10 November 2019  
Zac Langsford  
Assistant Development Manager  
Mirvac Projects Pty Ltd  
Office and Industrial  
Level 1, 2 Davy Road  
Eveleigh NSW 2015

## RE: Locomotive Workshop, B44 & B35 Conditions of Consent – Glazing

Figure 4 | Heritage arched window – external view (left) and internal view (right)

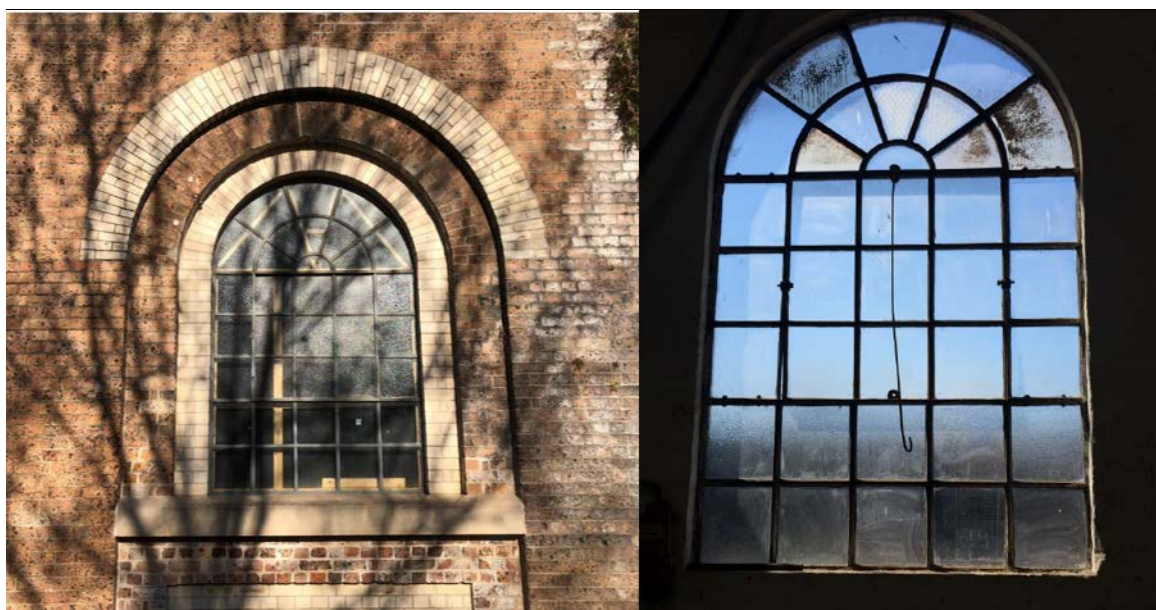
Mirvac and Curio have identified that a significant amount of the glass panels of the heritage arched windows are currently in poor condition and require replacement. Most of the early and original glass panels are frosted. Currently, the conditions of consent require that the replacement of broken frosted or opaque glass panes must use clear glass panes, as described in the glazing conditions of consent B44 (SSDA 8517) and B35 (SSDA 8449) below;

The installation of clear glass panels together with the frosted and/or opaque original panes within one frame would be a major visual heritage impact on the original fabric of the building, and especially the heritage aesthetics of the arched windows.

Curio considers to be essential for the wording of the Conditions of Consent to be altered in order to ensure that the windows maintain their integrity and original quality, without having any visual impact on the heritage fabric of the building, as it will secure the new glass panels match the original ones surrounding them. The proposed wording is described below:

*All new external glazing used for the Locomotive Workshop is to be clear. Opaque or tinted glazing is only permitted in existing heritage arched windows to colour match surrounding tinted and/or opaque glazing within the same windows.*
